September 10, 2025

RE: EPC Comments – BLR Village C Rezone (ZONE-25-0020)

On behalf of Clayton Properties Group II, A Colorado Corporation DBA Oakwood Homes, we respectfully submit the following responses to the review comments dated July 09, 2025.

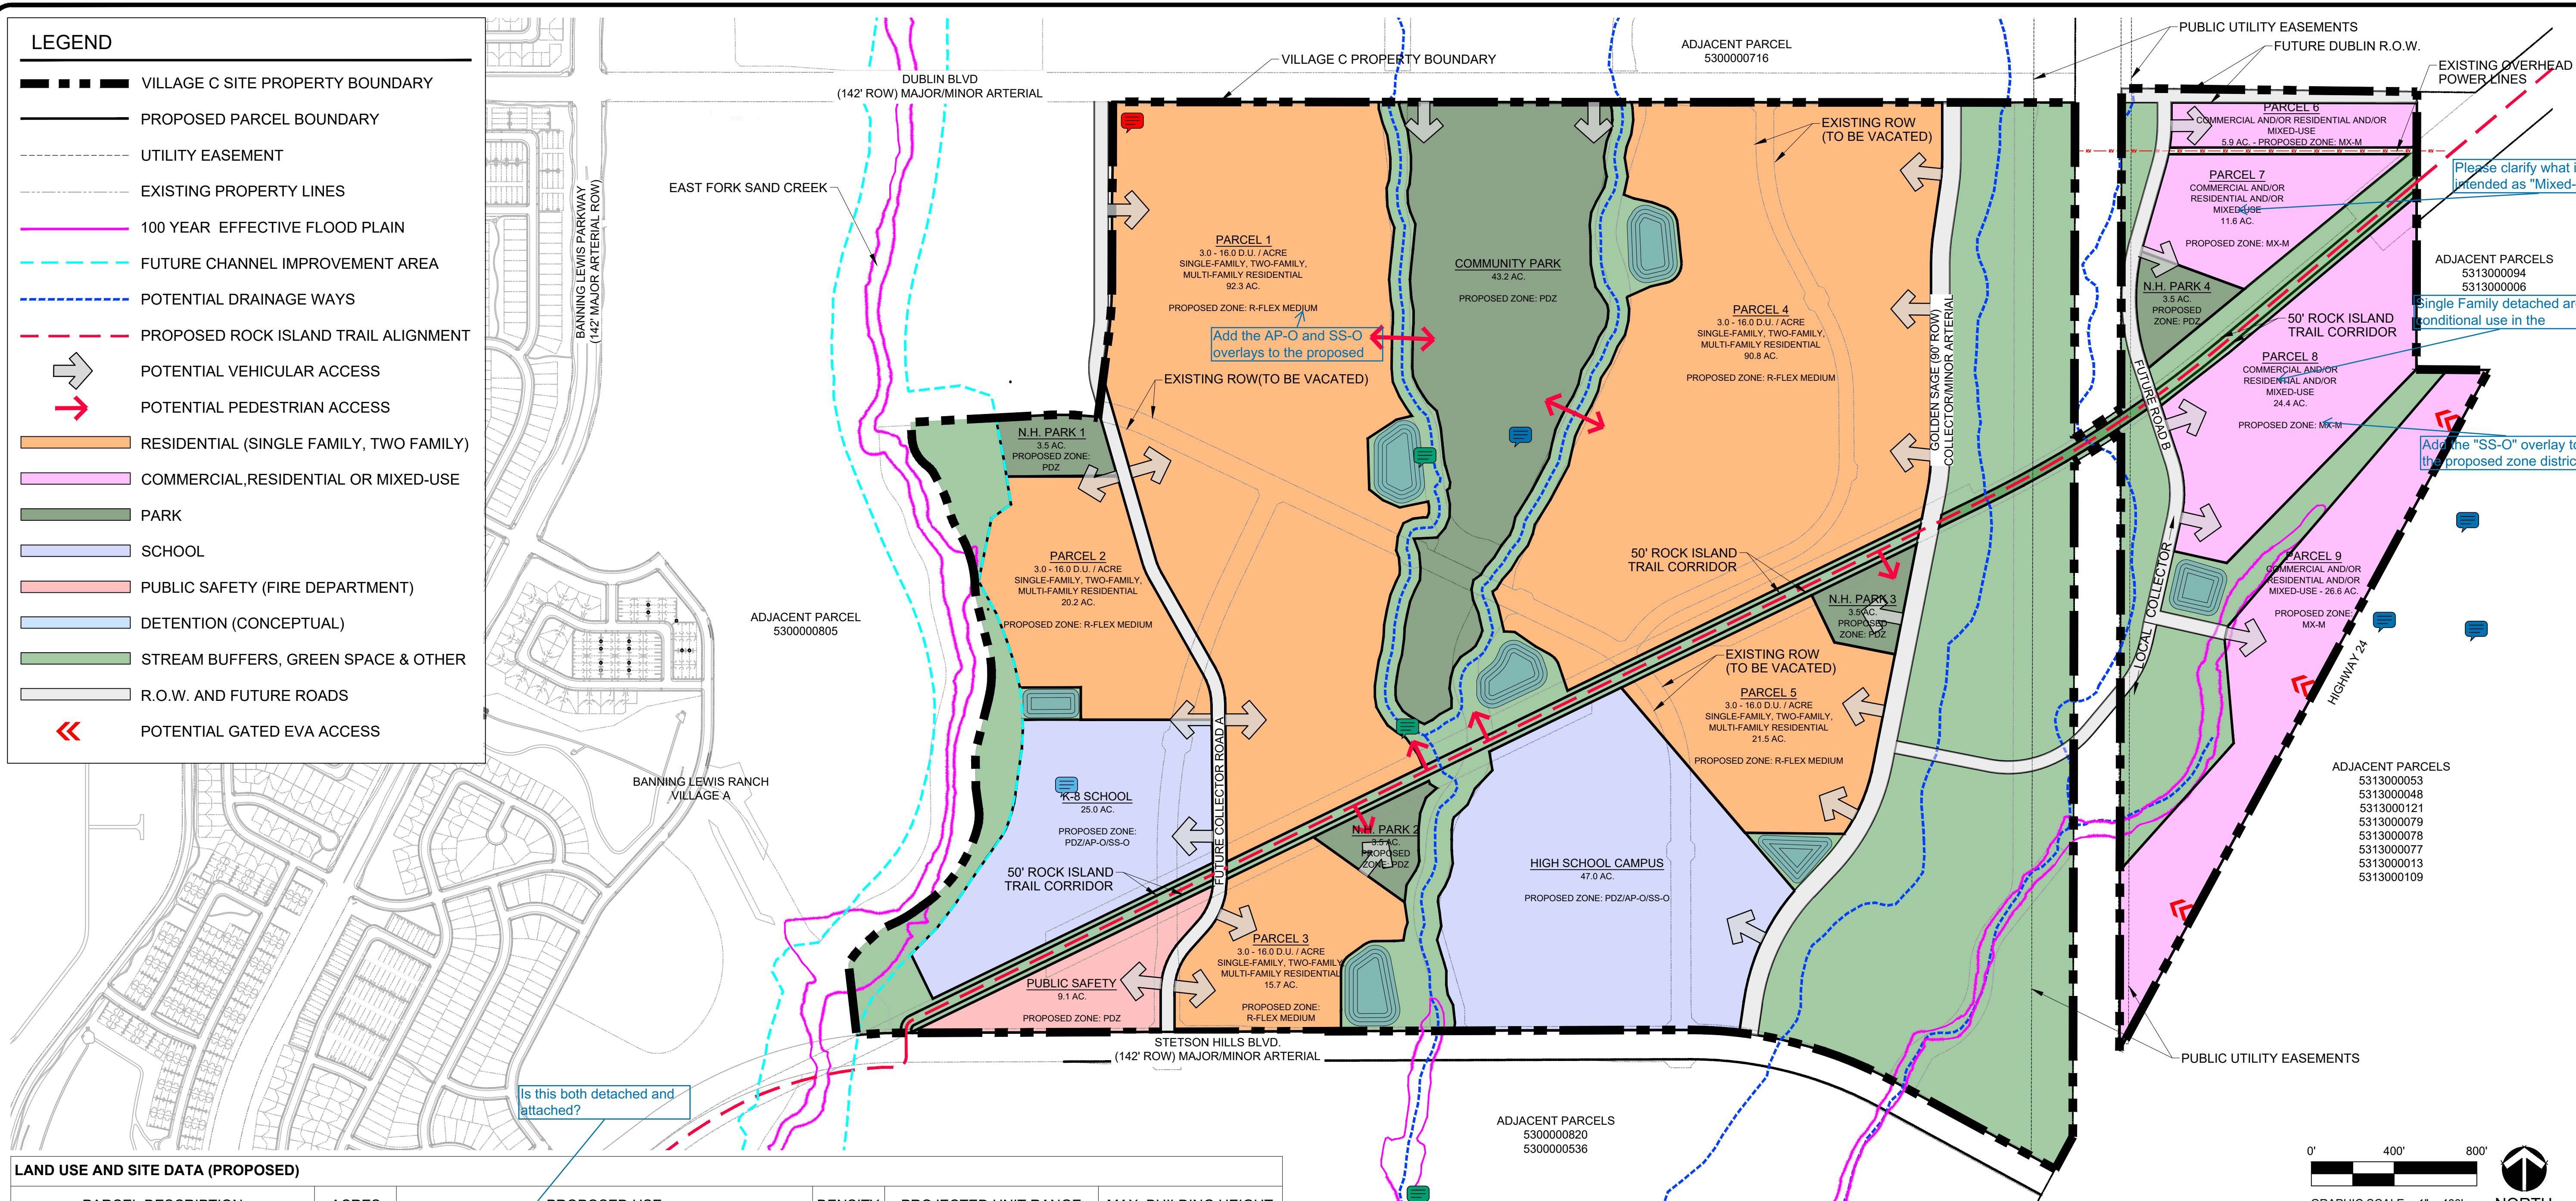
1. Please coordinate with the Falcon Highlands development on acceptance of drainage discharges and conveyances at the shared property boundary.

[Response: Noted.](#)

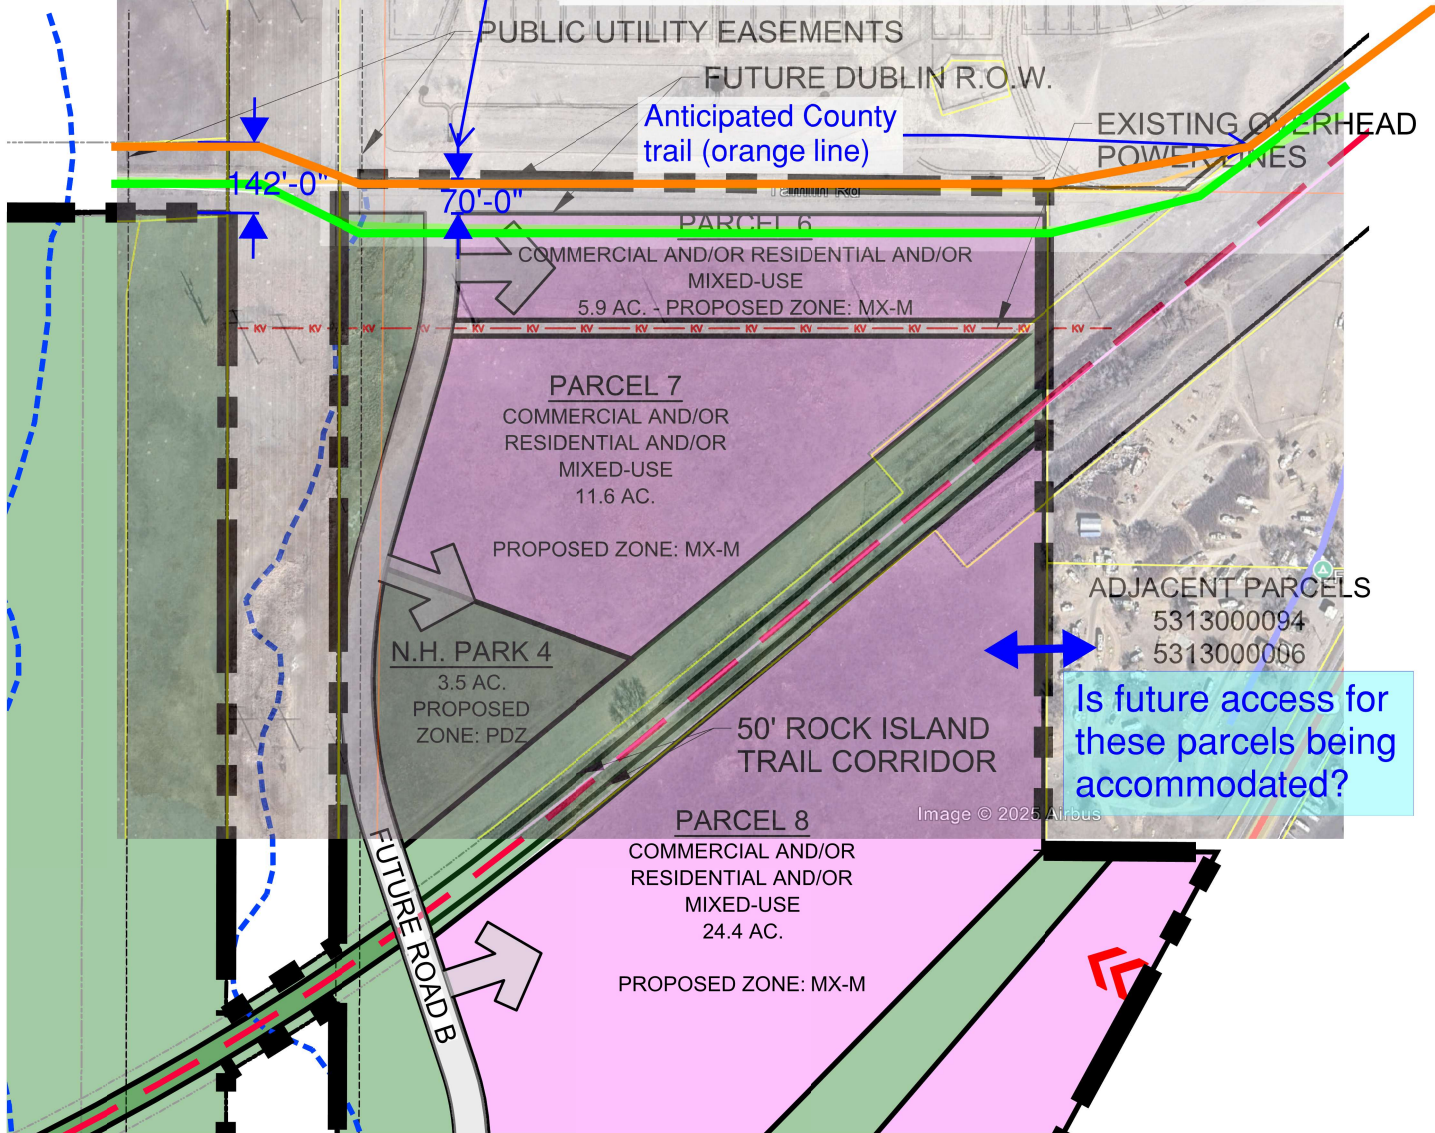
1. Note: Coordination is needed between the developer, the City and EPC (DPW and Parks) regarding the Dublin Blvd./Falcon Highway alignment. See attached sketch/redlines.

[Response: Coordination is on going. Current direction per meeting on 9/8/2025 with Jeff Rice, Todd Frisbie and development team is that BLR Village will dedicate at a future plat 70' to the ROW of a future Dublin ROW and an additional 30' will need to be provided from adjacent land owner or through city annexation or another method for 100' Minor Arterial through this area.](#)
